CITY OF PORTLAND

This is to certify that Gamage Mary E & /Greg Bar
has permission to Expand mudroom 4' x 12', and install beam to span 6" of beam in kitchen
AT 142 Concord St 131 F028001

City of Portland, Maine - Building or Use Permit Application

Proposed Project Description:
Expand mudroom 4' x 12', and install beam to span 9'-6" of bearing in kitchen

MARY GAMAGE / JEFF GRIFFITHS 142 CONCORD ST. PORTLAND, ME		
SCALE: $\frac{1}{4}'' = 1'-0''$	APPROVED BY	DRAWN BY MK
DATE: 12/03		
KITCHEN RENOVATION - PRELIMINARY		
		DRAWING NUMBER

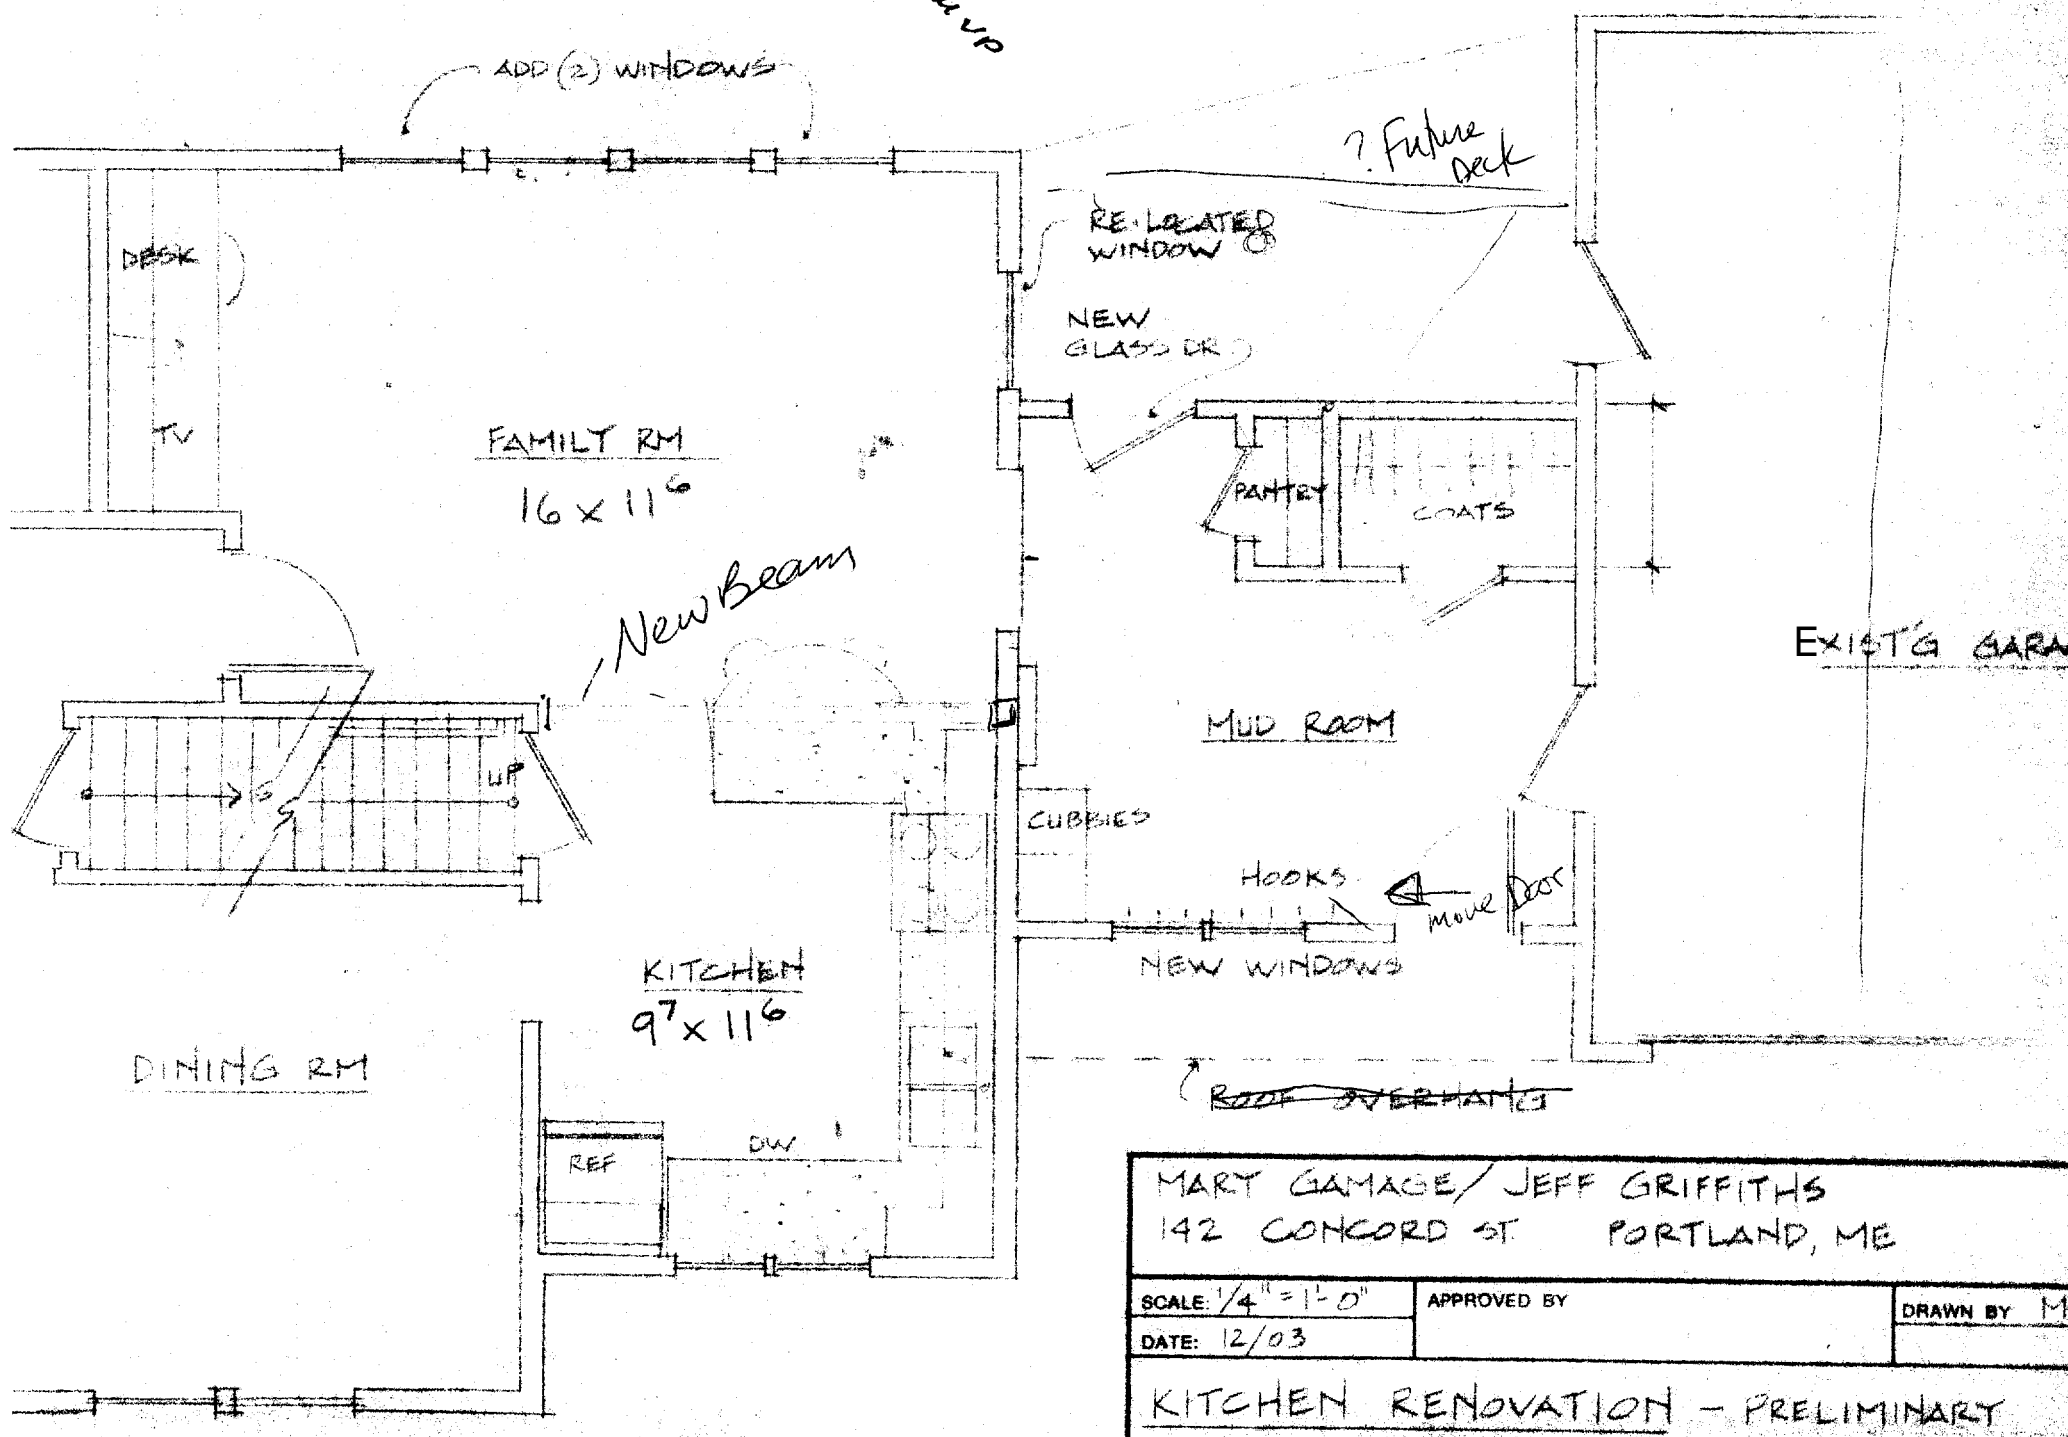
- 1) If the owner decides to change the roof/ceiling design to a cathedral or elevated ceiling, a construction design shall be submitted to this office prior to framing.
- 2) Permit approved based on the plans submitted and reviewed wownerlcontractor, with additional information as agreed on and as noted on plans.
- 3) Separate permits are required for any electrical, plumbing, or heating.
